Consultation Response from KC, Conservation and Design**2019/93525 8, Morley Lane, Milnsbridge, Huddersfield, HD3 4NZ****Erection of advertising hoarding (within a Conservation Area)****Date Responded: 11.5.20****Responding Officer: Sue Oakley****Responding Ref:**

Advertising Billboard Application. March 2020

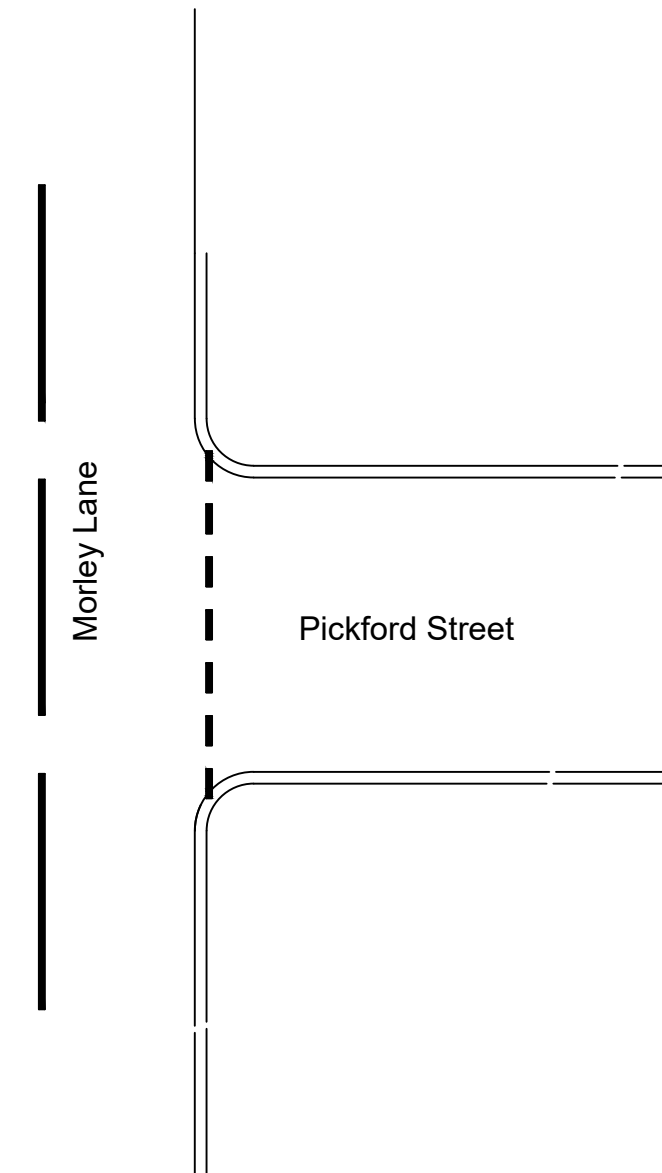
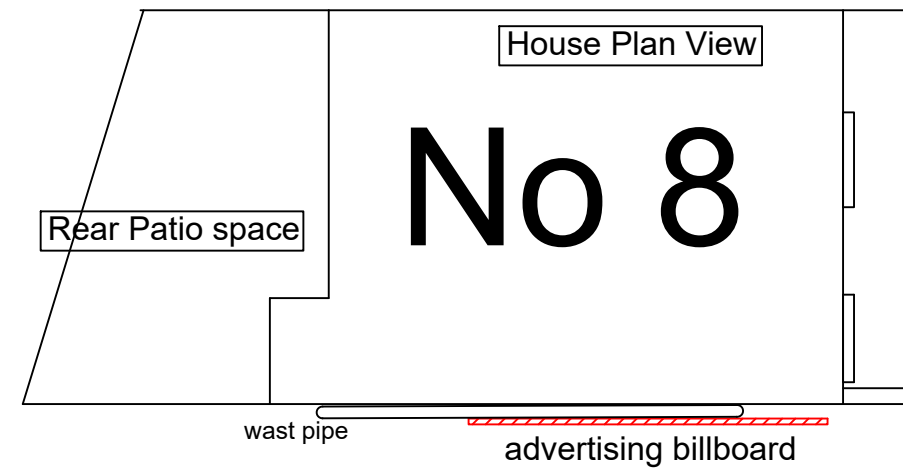
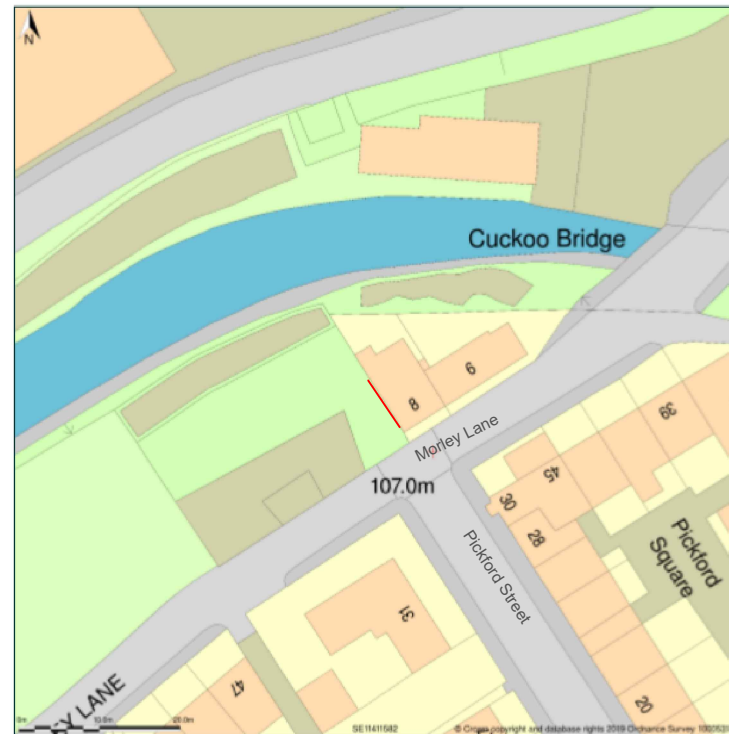
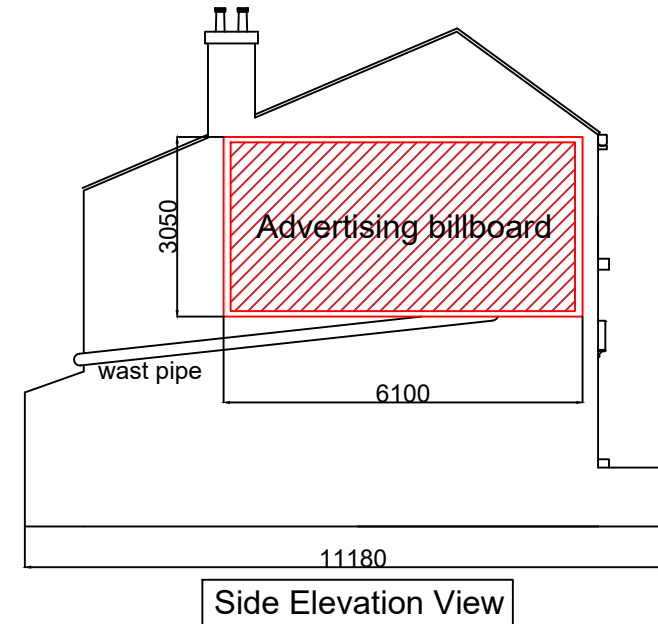
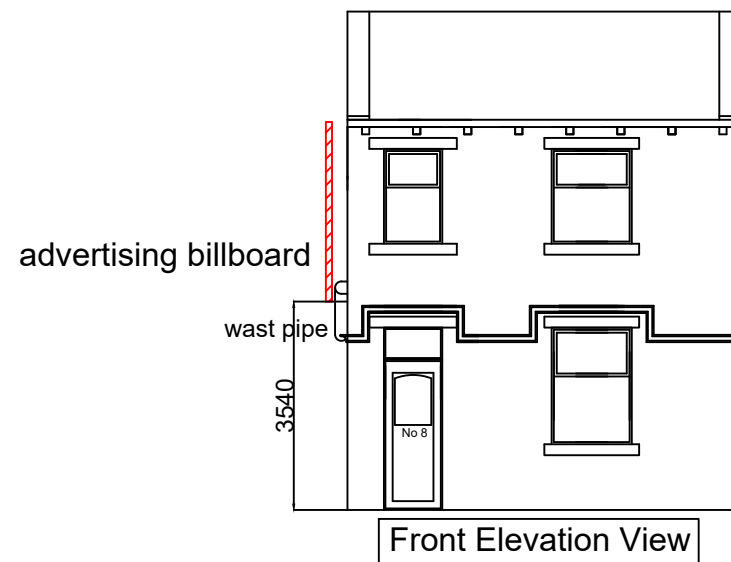
The gable end is highly visible when approaching the Milnsbridge Conservation Area from the south west, downhill along Morley Lane, and I have some concerns that a large advertisement hoarding will detract from the view of the conservation area and cause slight harm to its setting. I do not consider that it will harm the setting of the listed bridge.
